Your ref: K/19/19/HH

Re: Proposed re-development of Little Tangle, Kingston Gorse

I am writing to you on behalf of the Board of Kingston Gorse Estate (Sussex) Ltd. to register an OBJECTION to the proposed development of Little Tangle, Middle Way Kingston Gorse.

Proposed Section AA

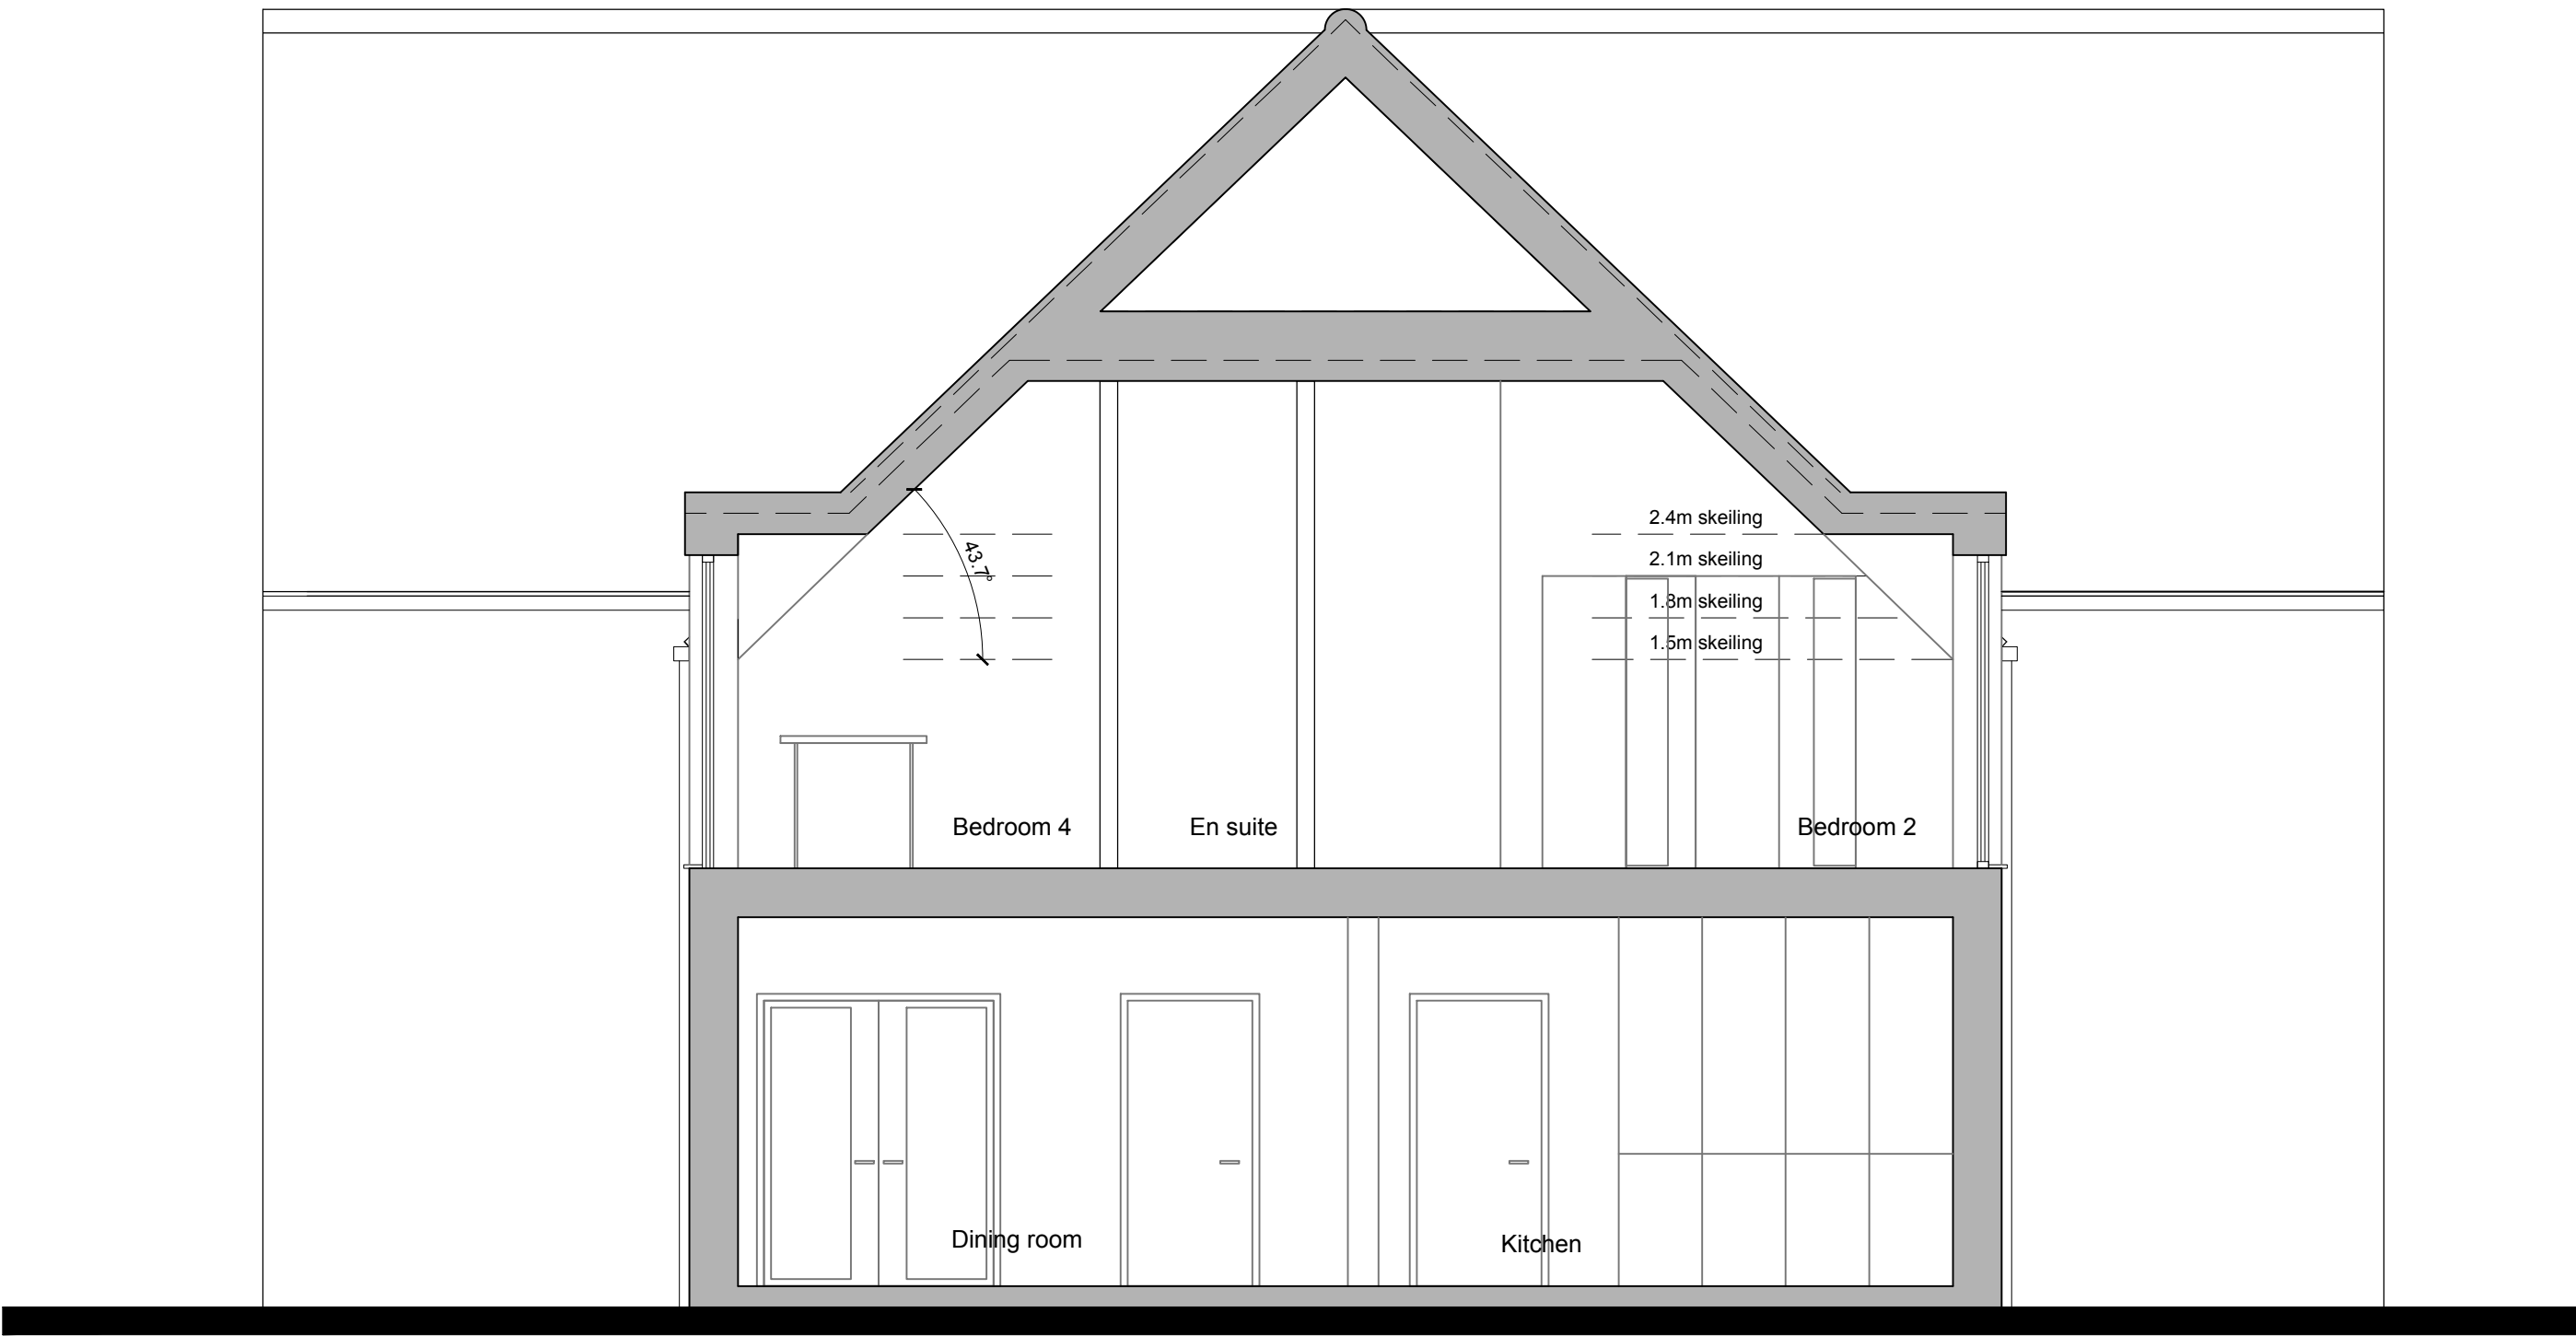
The existing property is a dormer bungalow, which is to be replaced by a two-storey dwelling. The proposed ridge-line of the new property will be increased by over 31%, from 11.61m to 15.27m. The existing single storey sun room will be replaced by a two-storey gable entrance to the house. Both these features will lead to a loss of light, particularly for the residents of Clova, where the kitchen window will now be obscured by the higher elevations, which will also impact on the view from the window.
